Our Ref: FP/193/17/HH
Your Ref:

Town & Country Planning Act 1990 (as amended)
Town & country Planning (Development Management Procedure) (England) Order 2015
Application for Planning Permission for Works or Extension to a Dwelling

Development Proposed extensions
Location 5 Roundle Avenue Felpham

Existing South Elevation

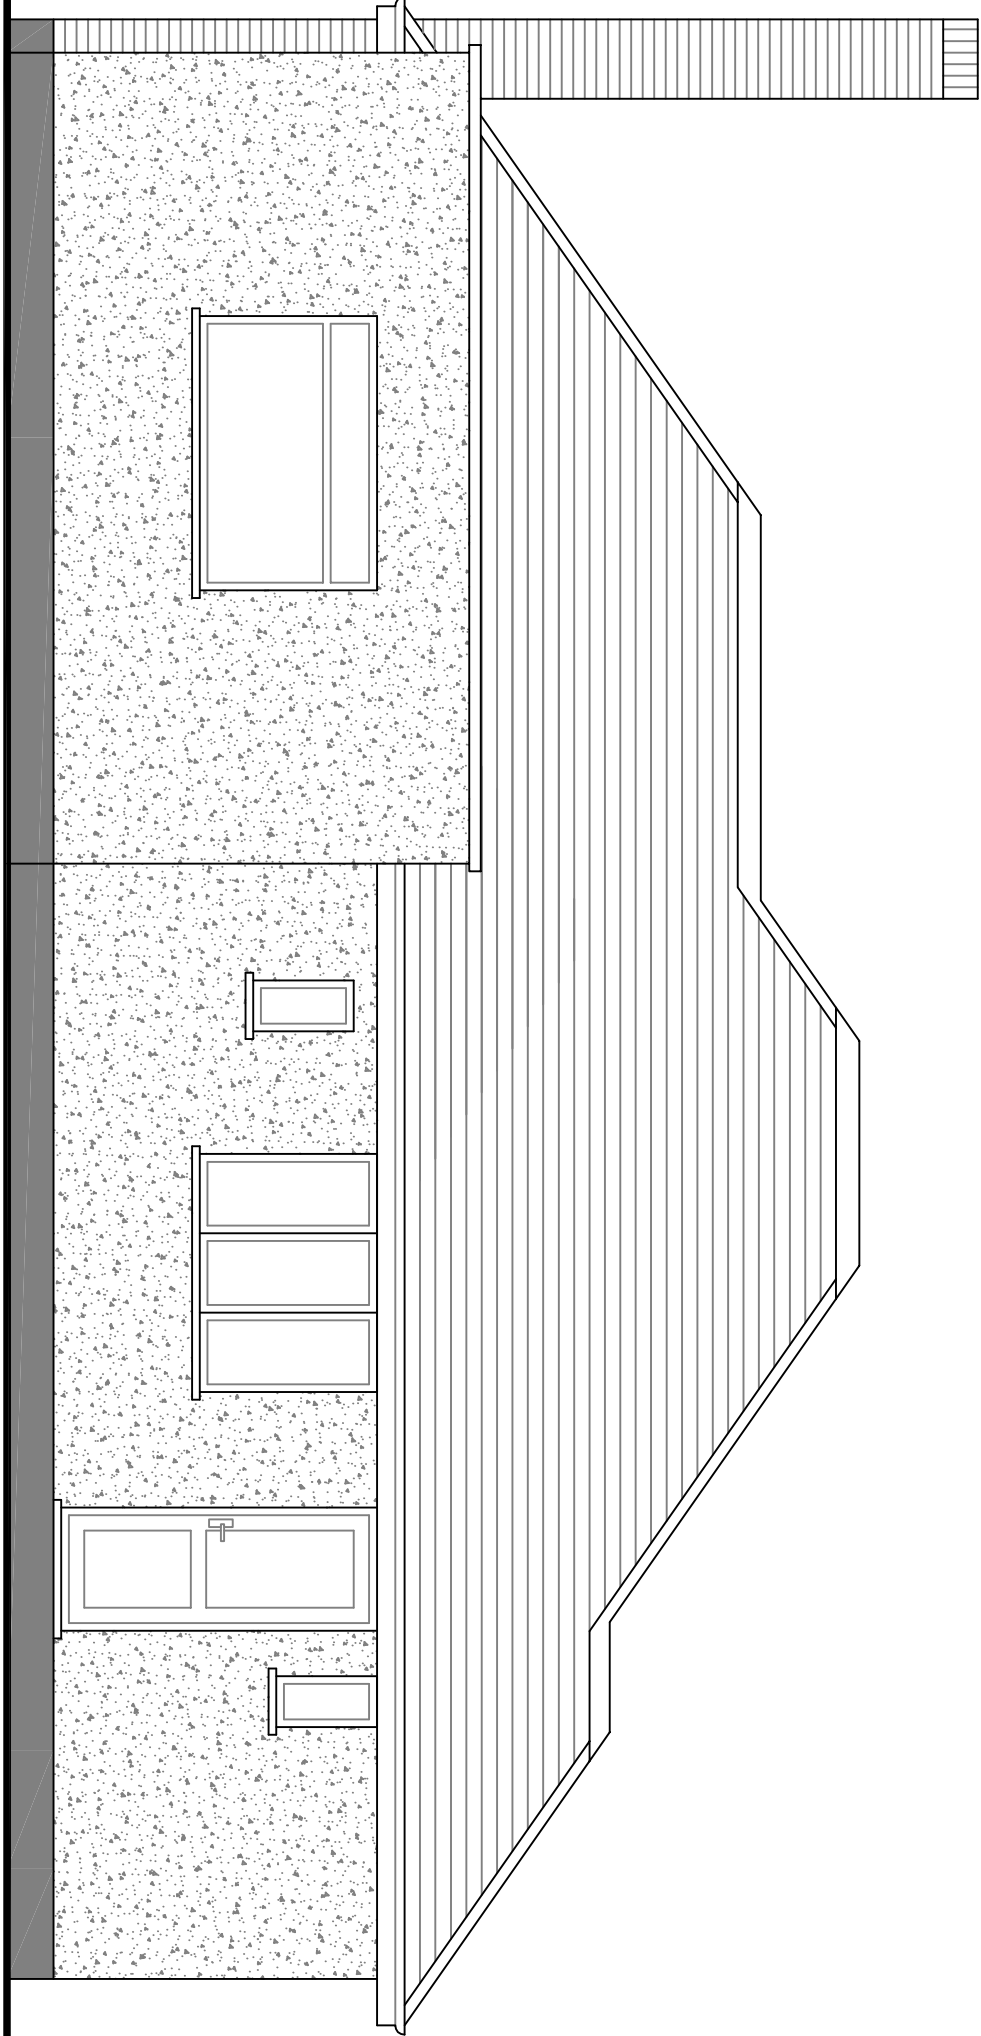
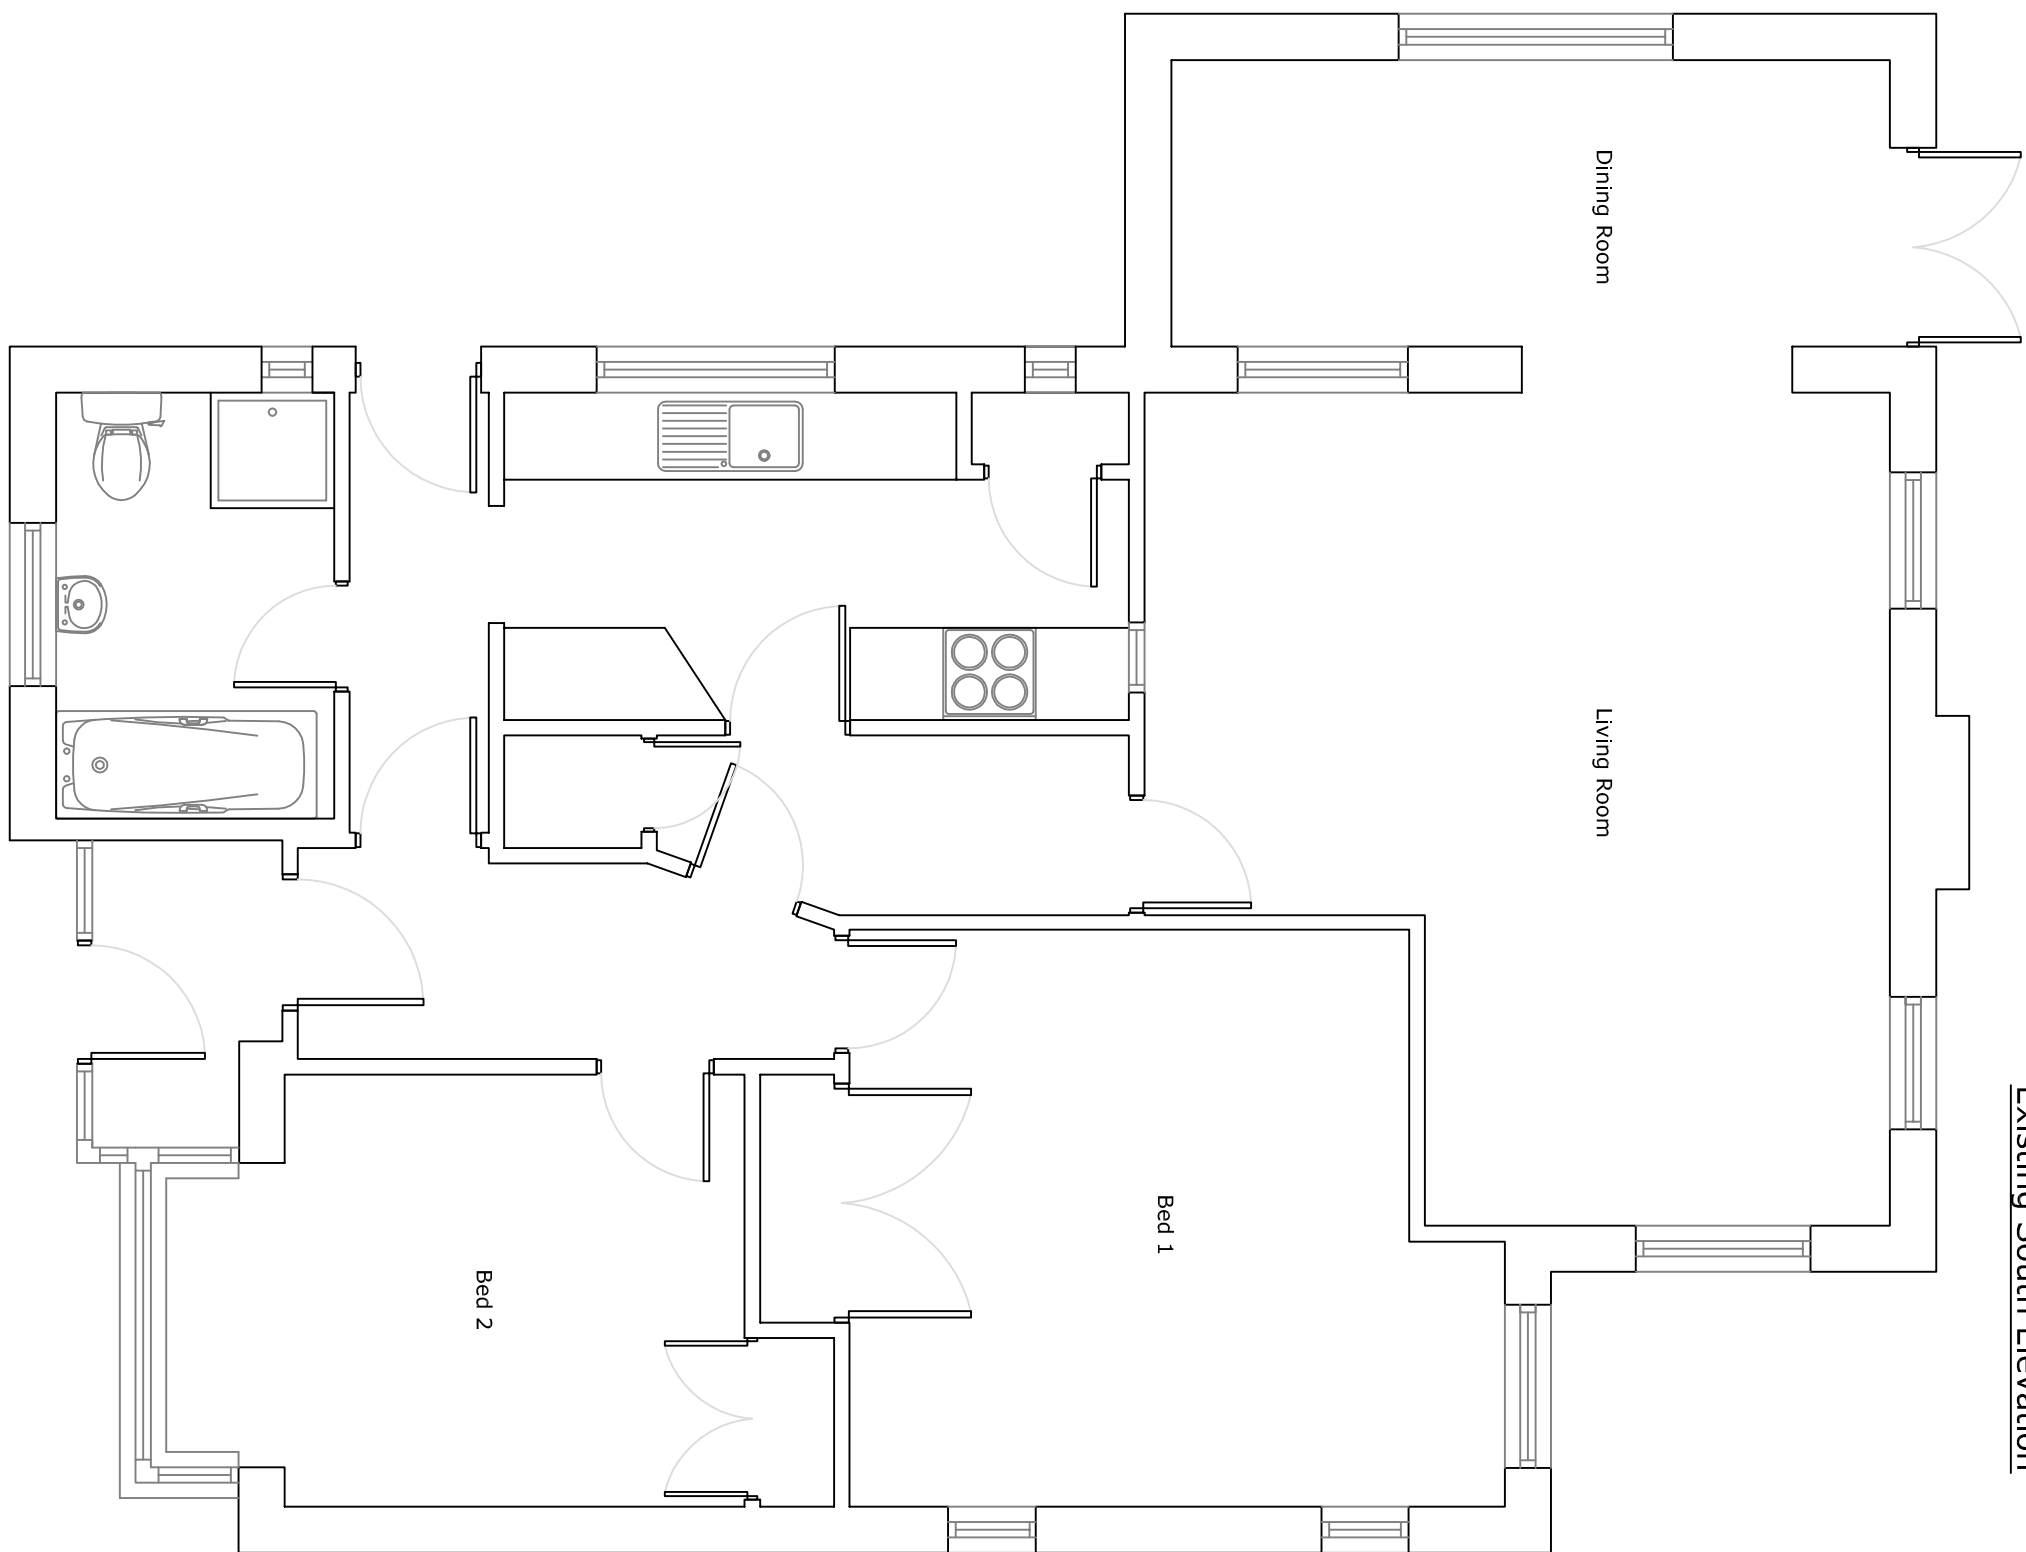
The existing south elevation and floor plan do not accord. Please amend accordingly.
